From: Mark Jones
Sent: 30 March 2017 13:30
To: Planning
Subject: FW: 40 Bursledon Close
Importance: High

From: Mark Jones <[REDACTED]>
Date: 30 March 2017 at 12:13:47 BST
To: '[REDACTED]'
Subject: 40 Bursledon Close

I am dealing with your planning application. I have noticed there may be a discrepancy between the block plan and the floorplans. The proposed elevations suggest the rear extension is set in from the side boundary approximately 0.5m however the proposed site plan and floorplans suggest it is up to the boundary suggest it is up to the boundary. Also the existing location plan appears to show the proposed extension could this be removed.

EXISTING LOCATION PLAN, Sc. 1:1250

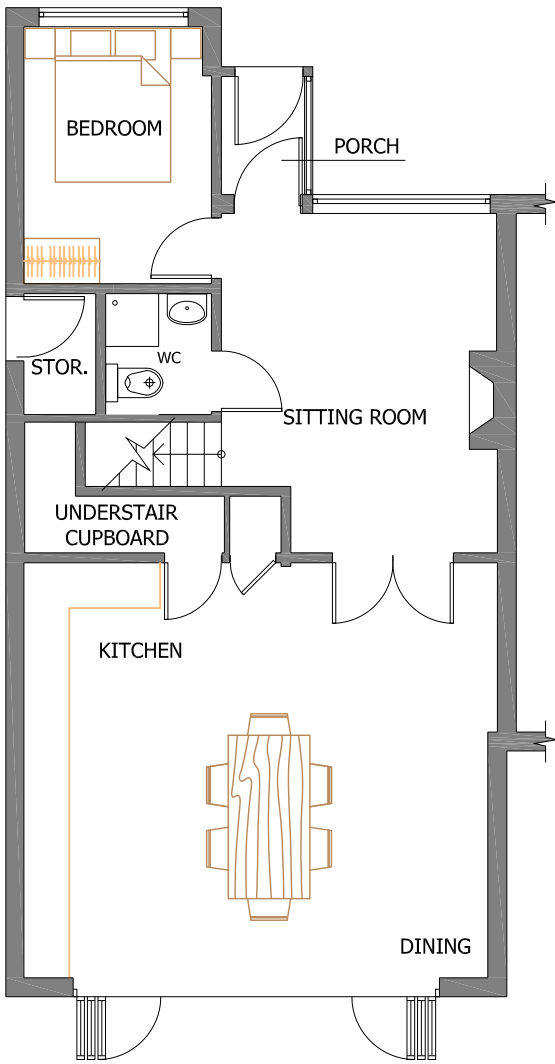
I would be grateful if you can amend the location plan and also if whichever of the proposed site plan or floorplans or elevations is incorrect please can you amend.

PROPOSED REAR ELEVATION

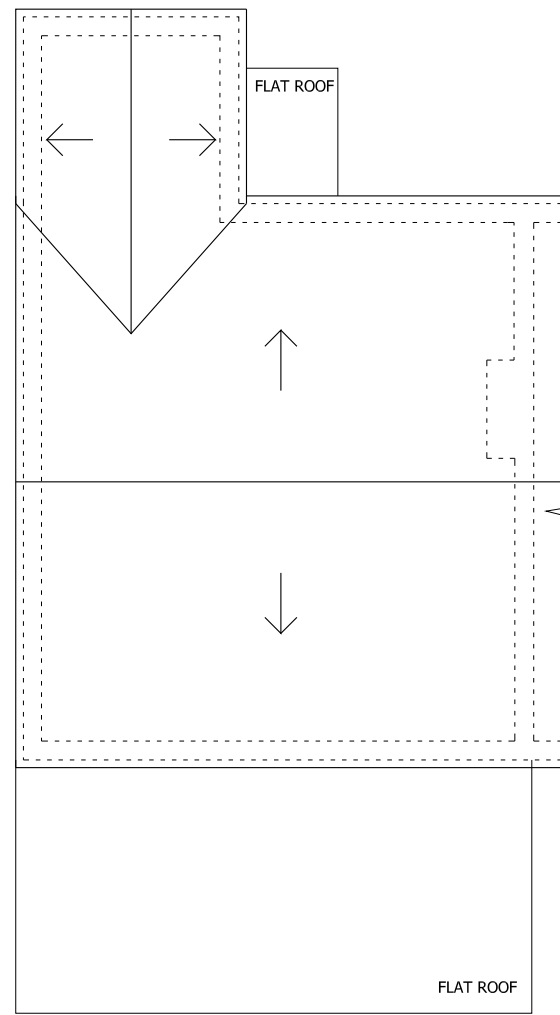
In addition can you clarify what the white band is on the rear elevation of the proposed rear extension if this is part of the roof the height is different from the height measured on the side elevation. Therefore, if you can clarify this aspect also
